Application no: **3/2022/0196**

Address: **15 Abbey Road Whalley BB7 9RP**

Proposal: **Demolition of existing garage and construction of single storey extension to side and rear.**

proposed layout

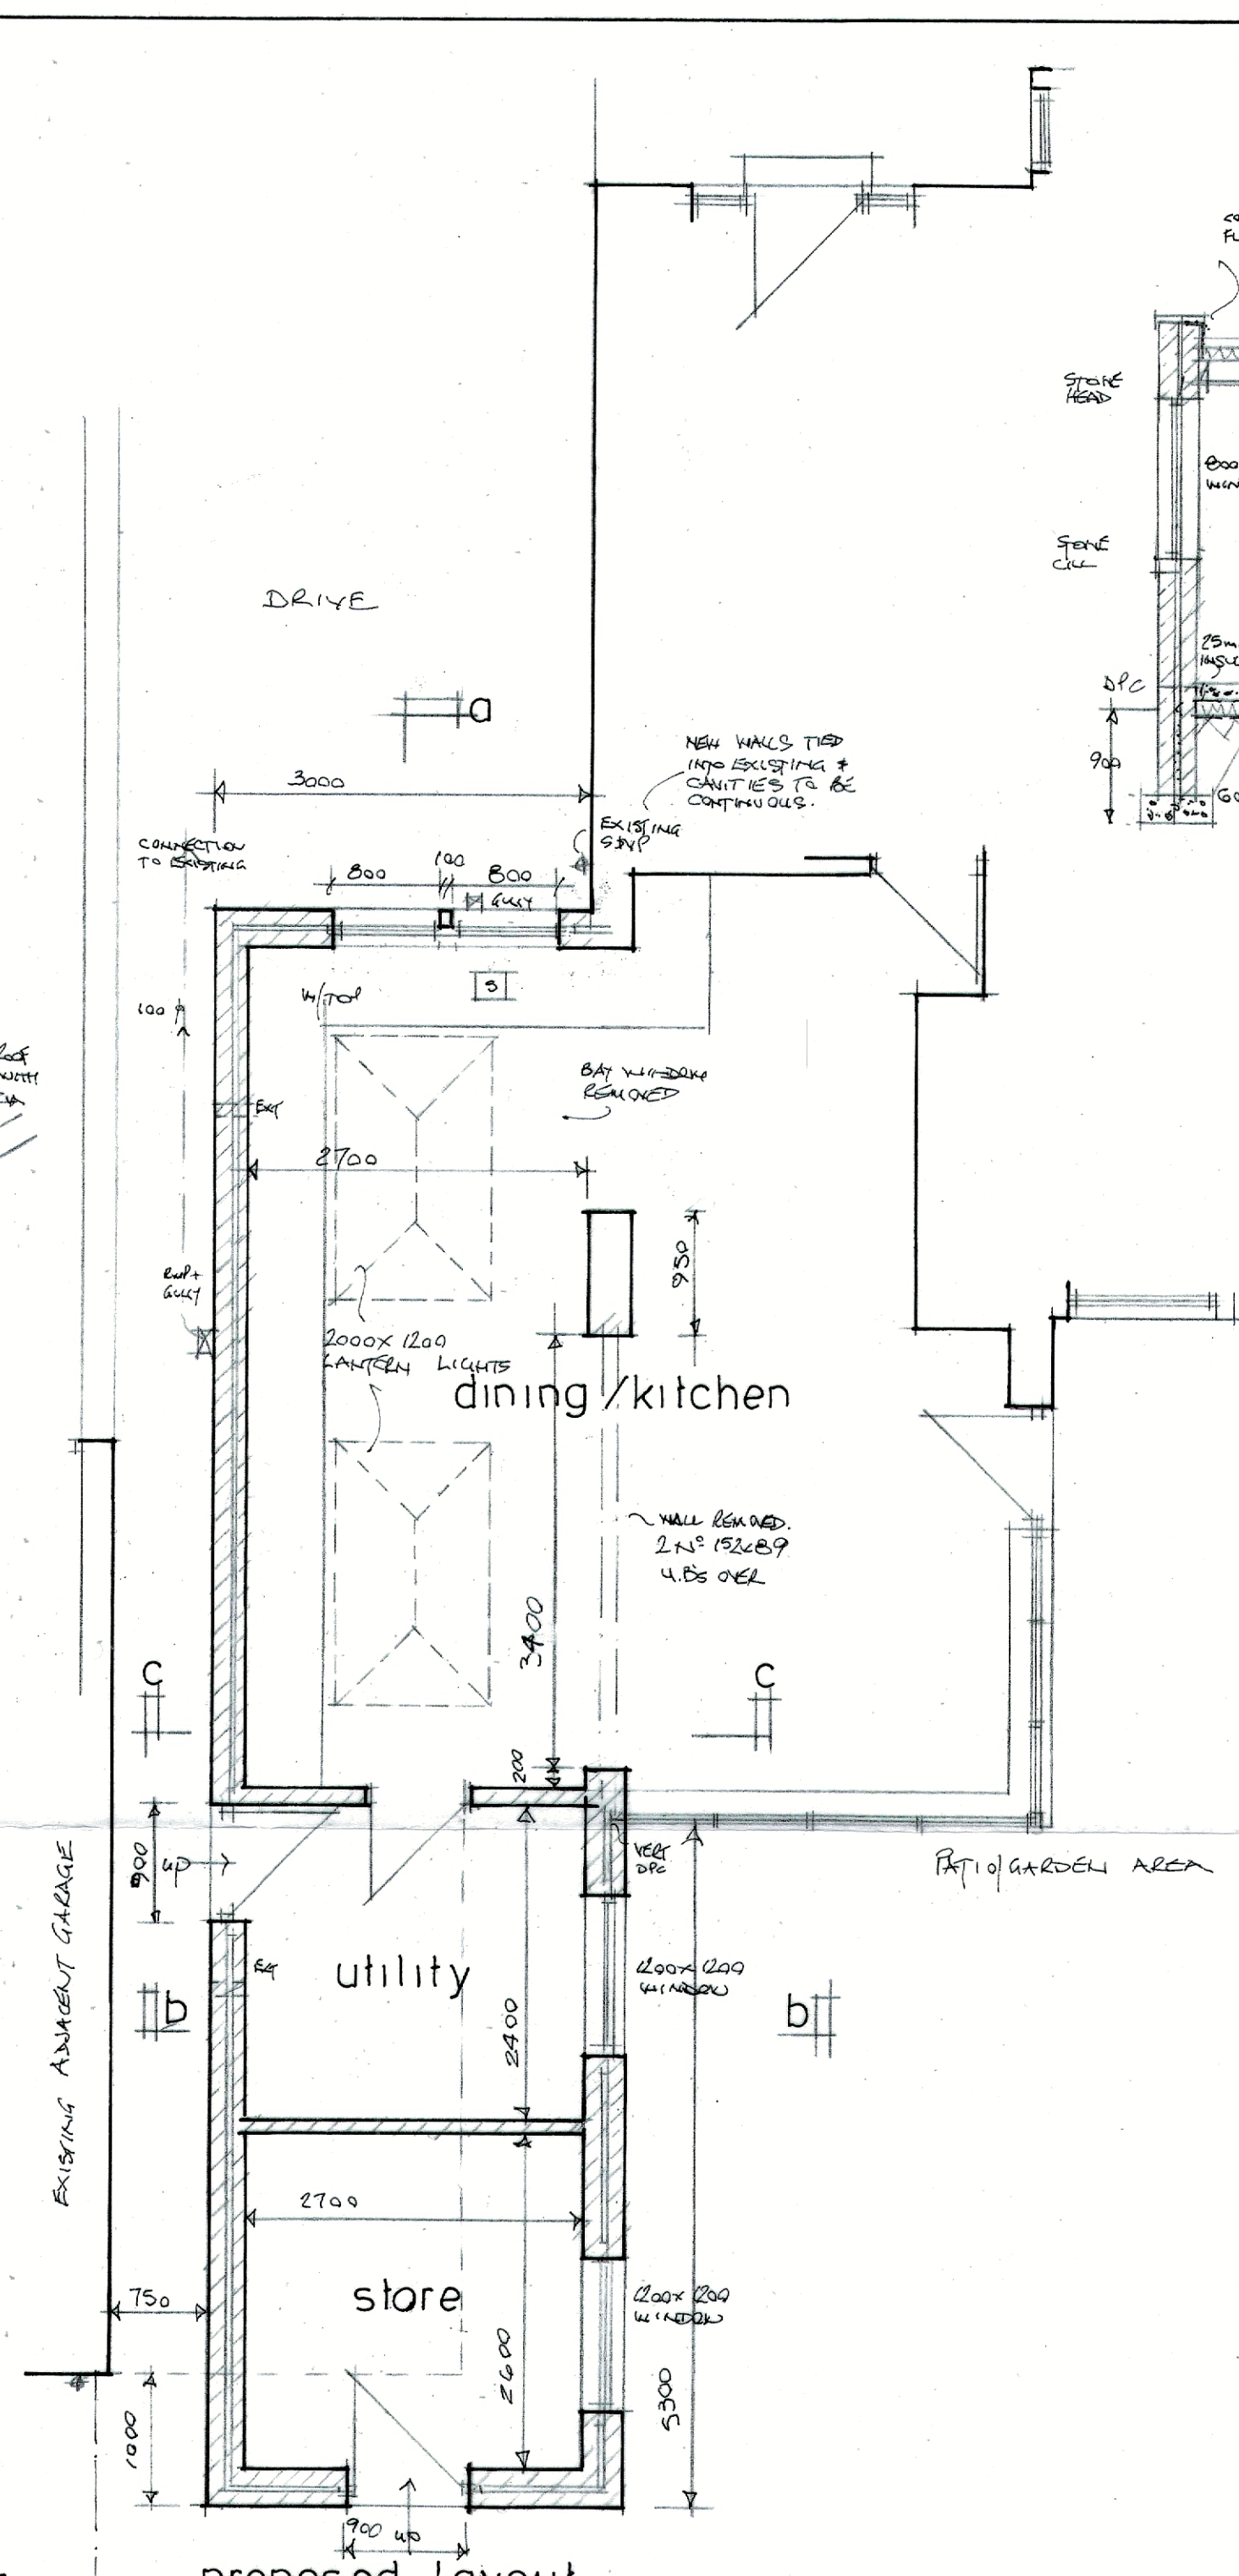
However, before the LHA can comment on the application, the LHA require a parking plan showing how many car parking spaces can be provided on the driveway.

Details should also be submitted regarding how many bedrooms the dwelling has. This way, if there is a shortfall in parking at the site following the proposal, the LHA can assess whether they will accept the shortfall.
